Our Ref: TR010036

Date: 9 May 2019

**Application by Highways England for an Order Granting Development Consent  
for the A303 Sparkford to Ilchester Dualling Project**

**Proposed design changes to the original application**

Drawing Title
**FIGURE 2.4
RIGHTS OF WAY AND ACCESS PLANS - KEY PLAN
REGULATION 5(2)(k) and 5(2)(o)**

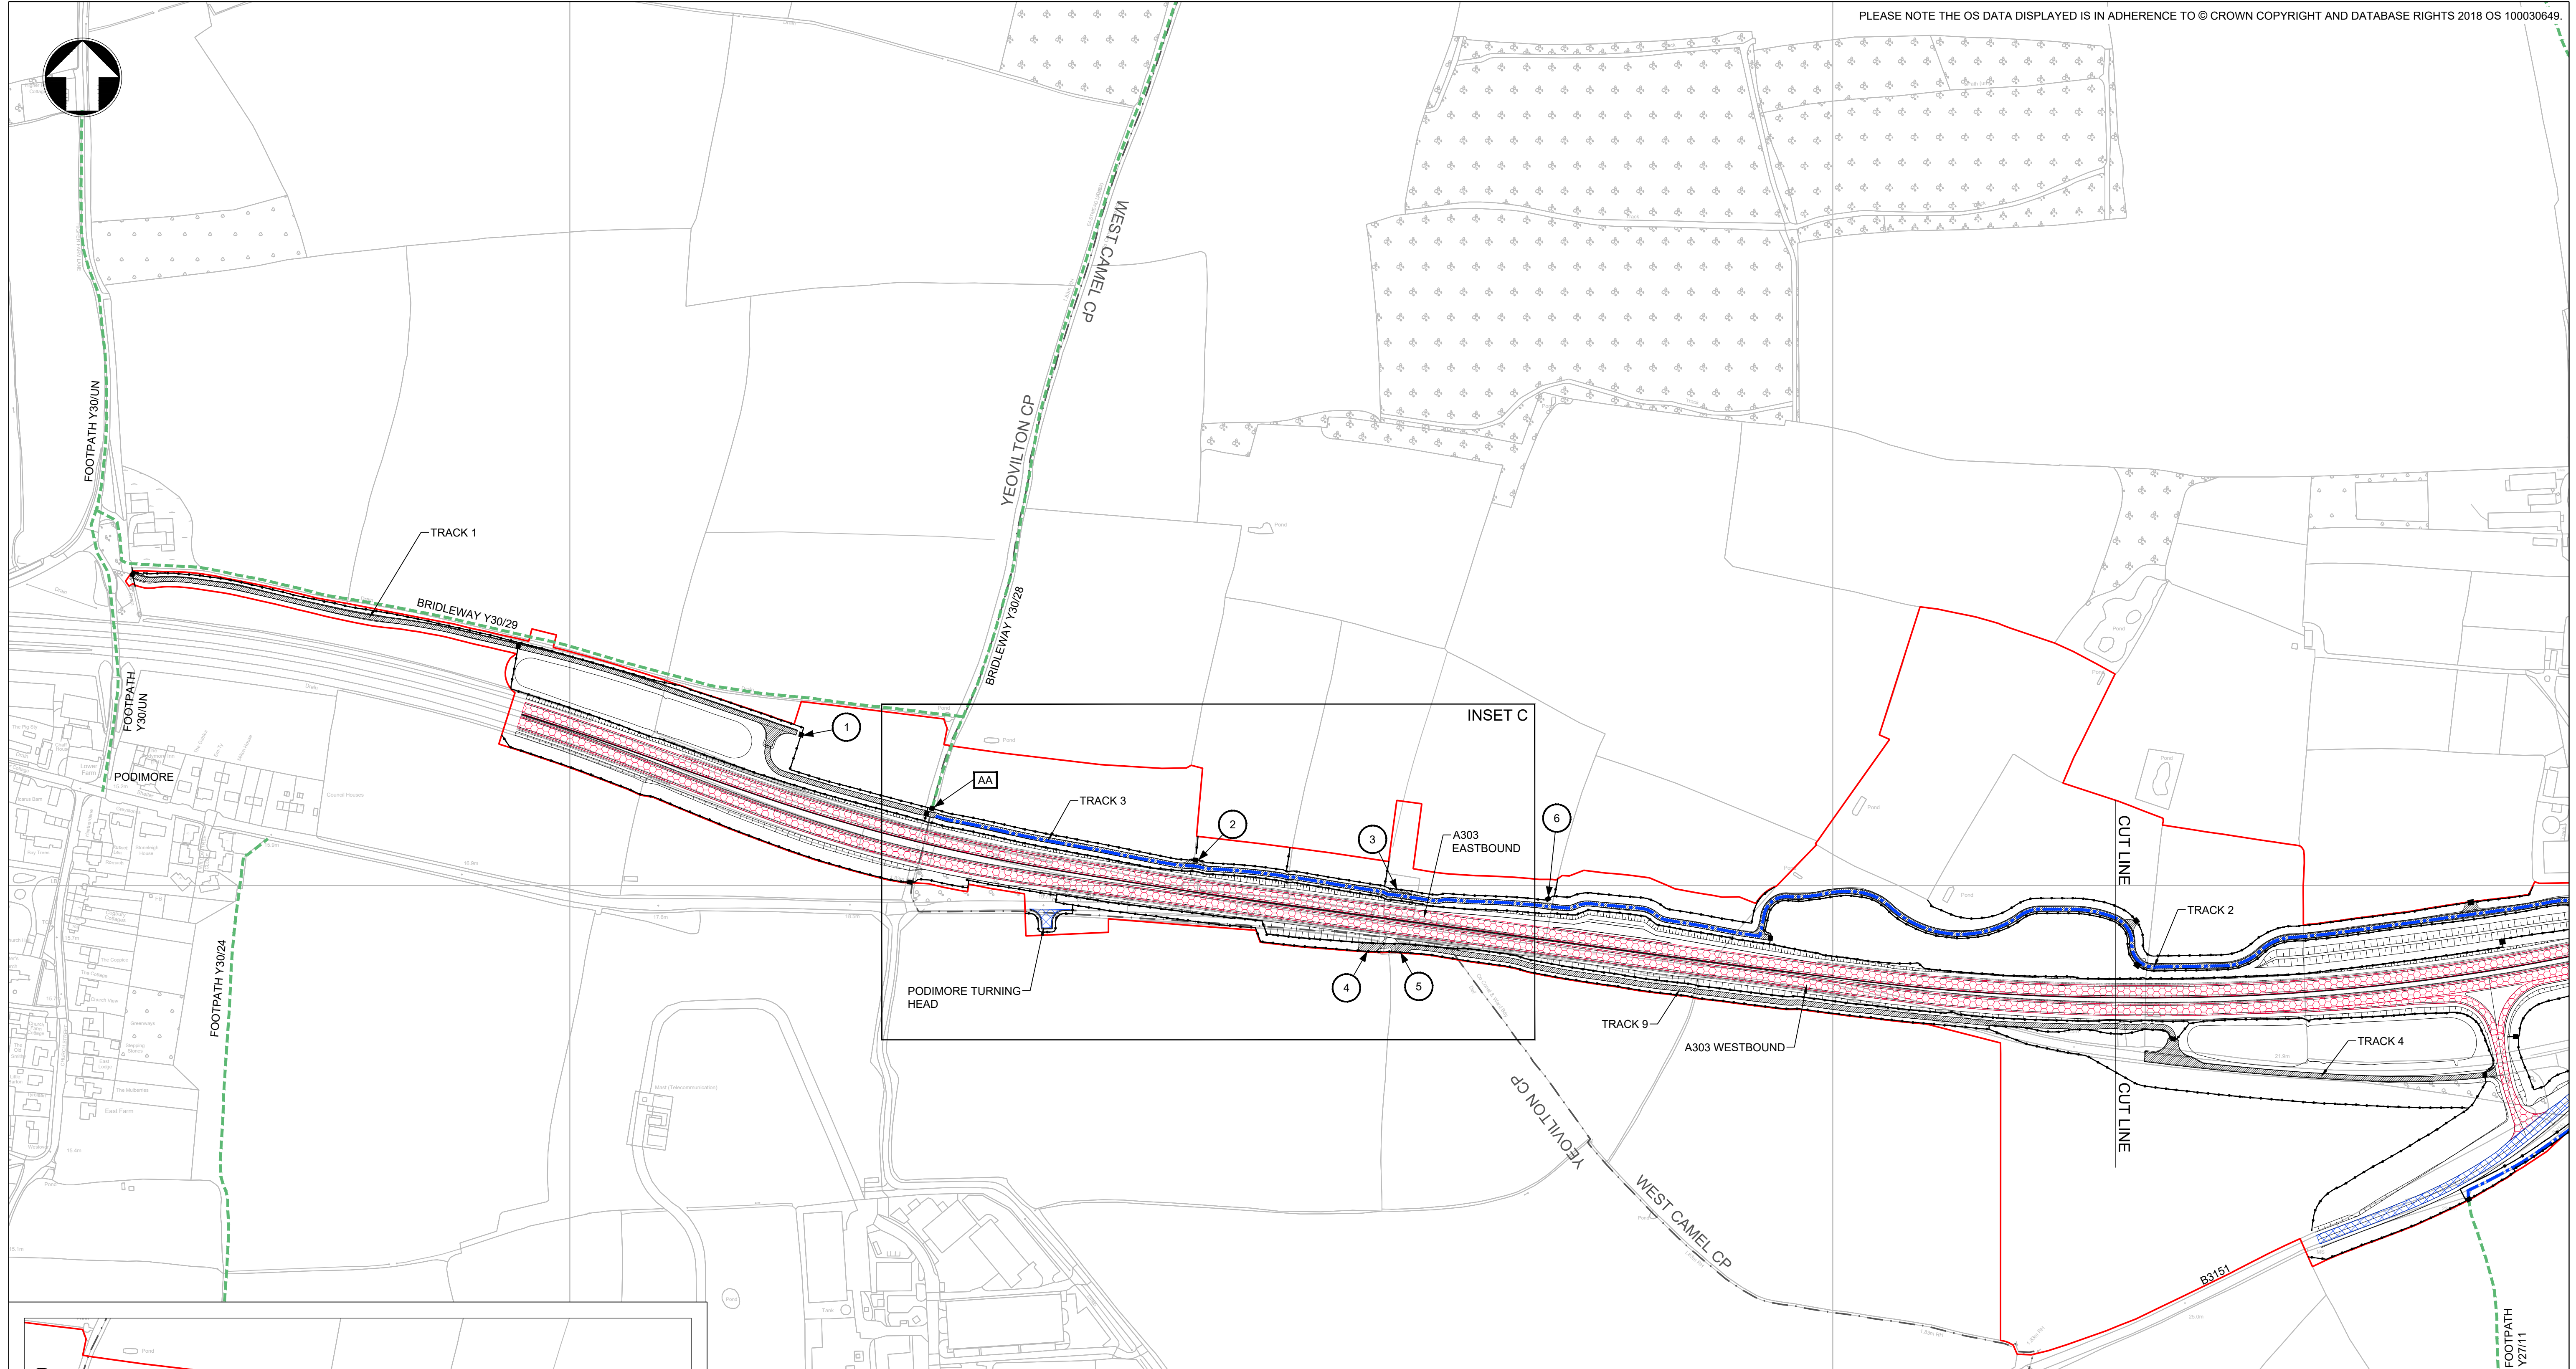
- To delete the more southerly of the two proposed footpaths between the east of Traits Lane and the west of Gason Lane (shown as plots 7/7a and 7/7c on the Lands Plans (Sheet 7) [REP5-002]).

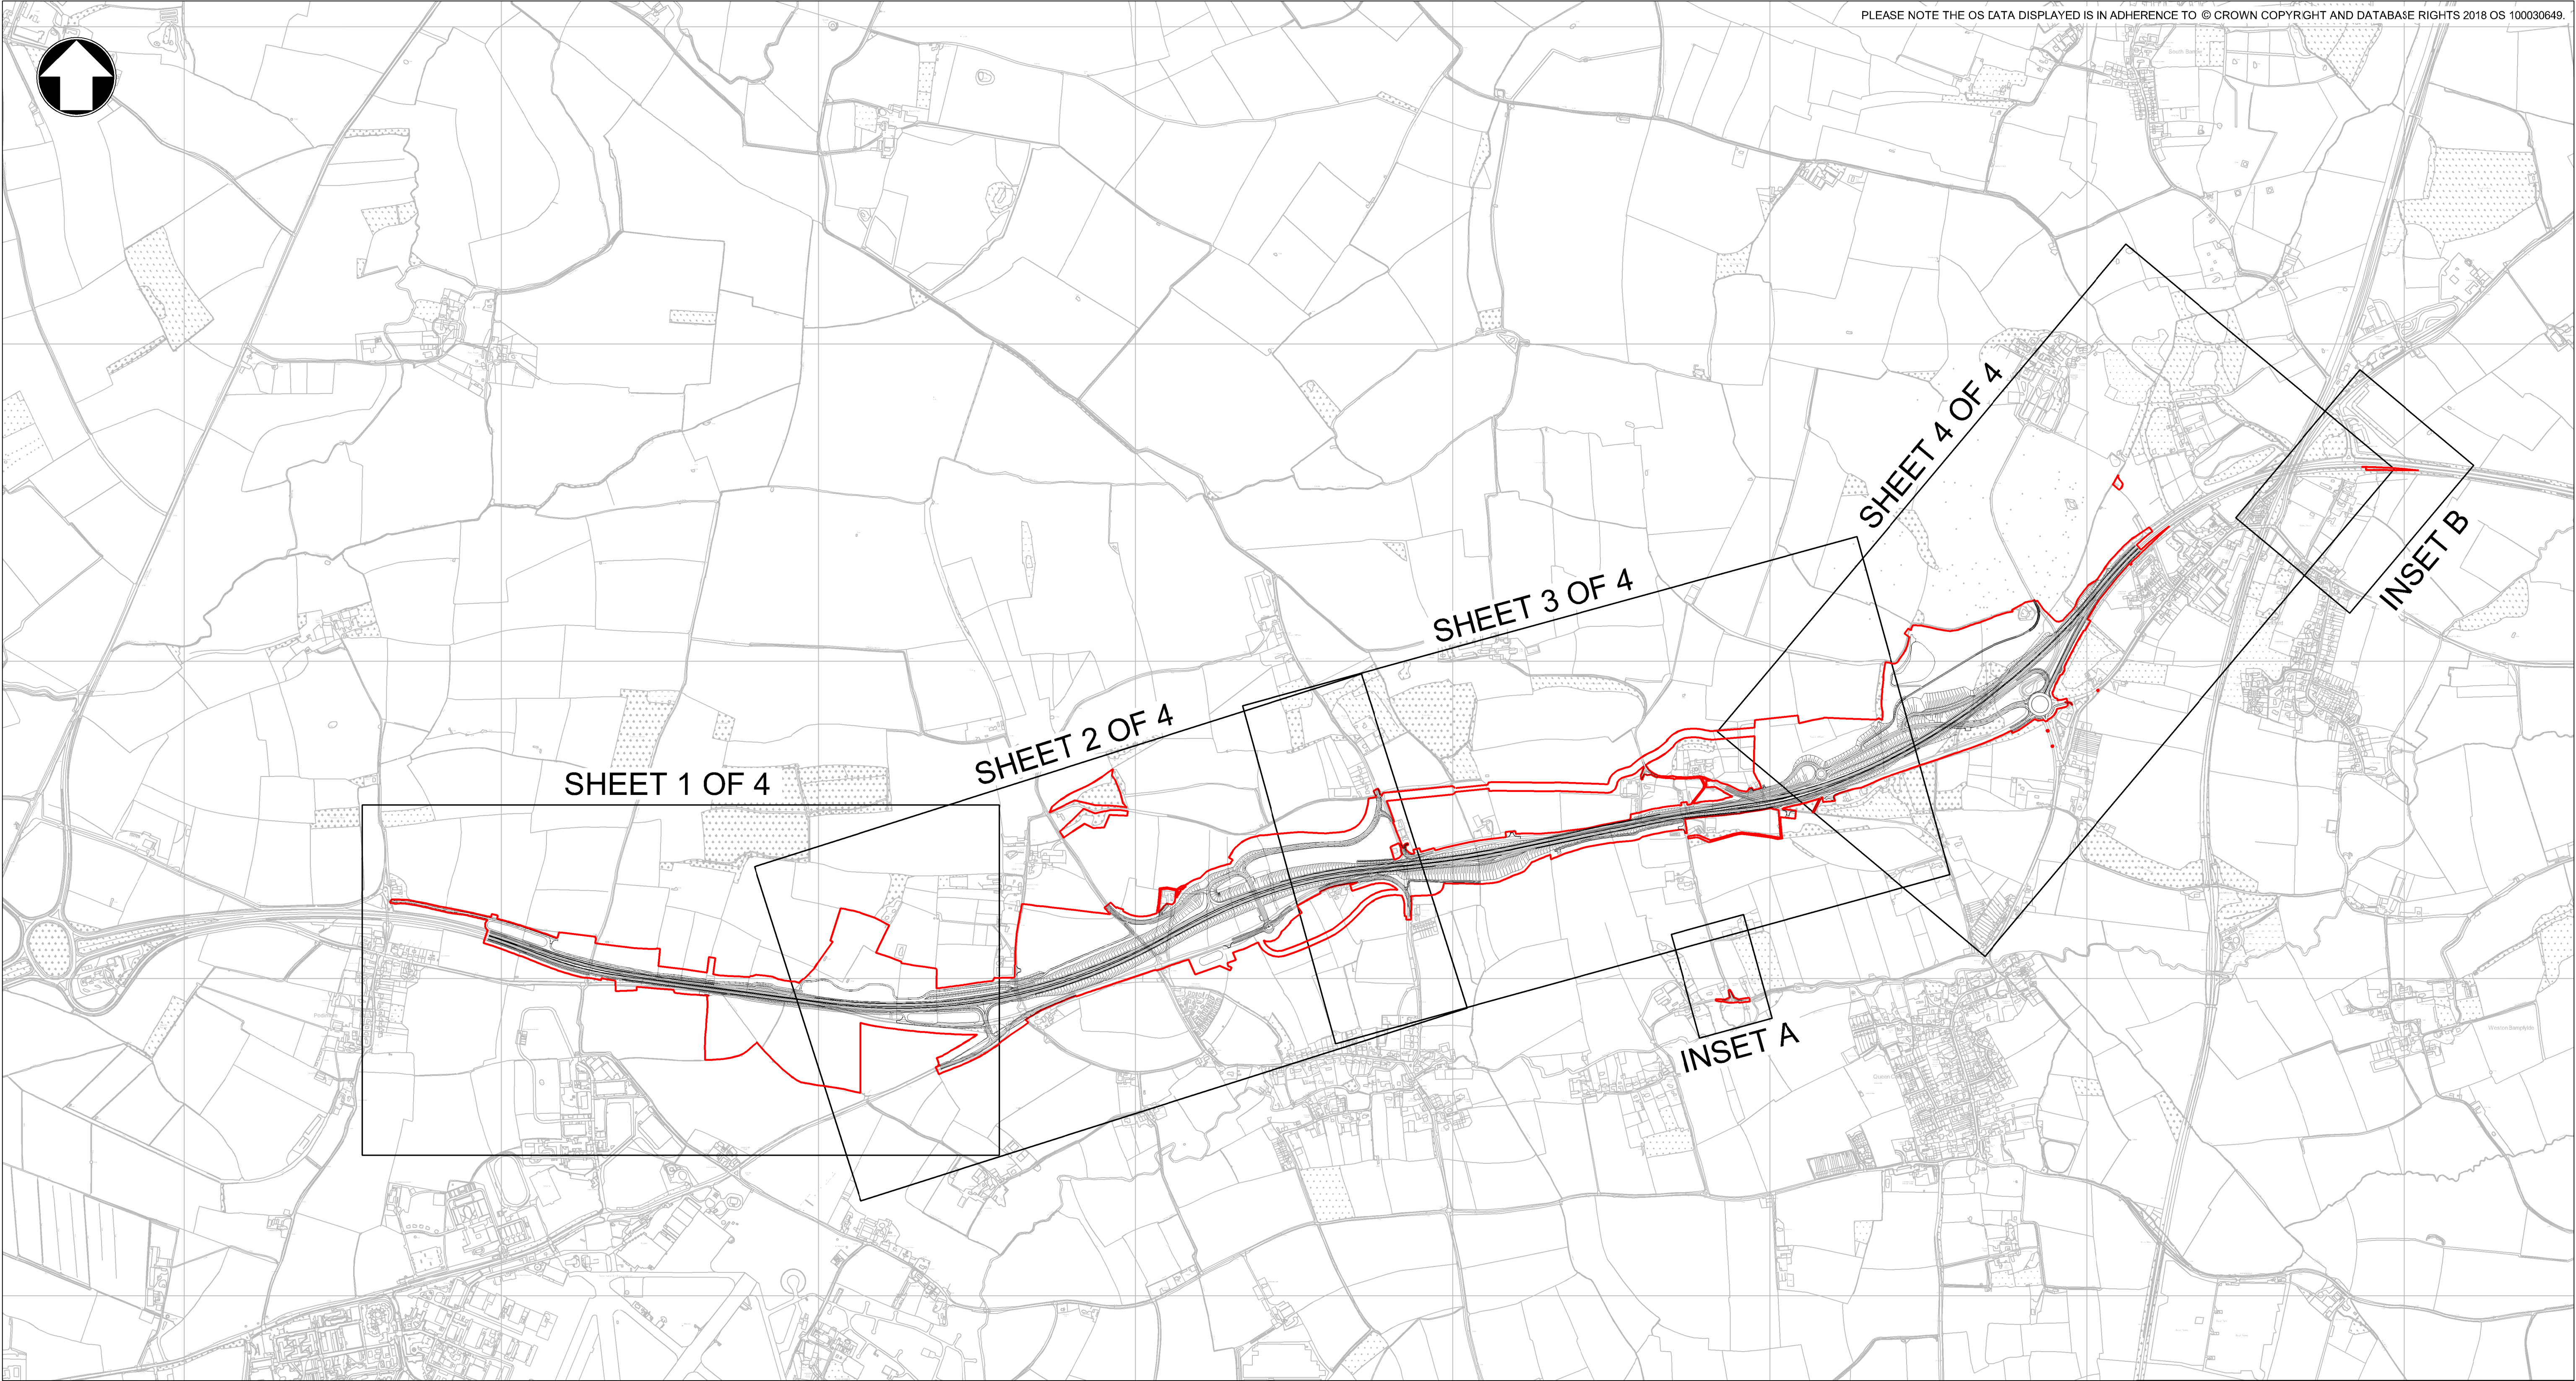
- Pond 5 – to move the proposed pond to the south and west and realign the maintenance track.
- Hazlegrove Preparatory School access – to realign this by approximately 20 metres northwards and provide additional planting between the realigned Pond 5 access track and the access track to Hazlegrove School.
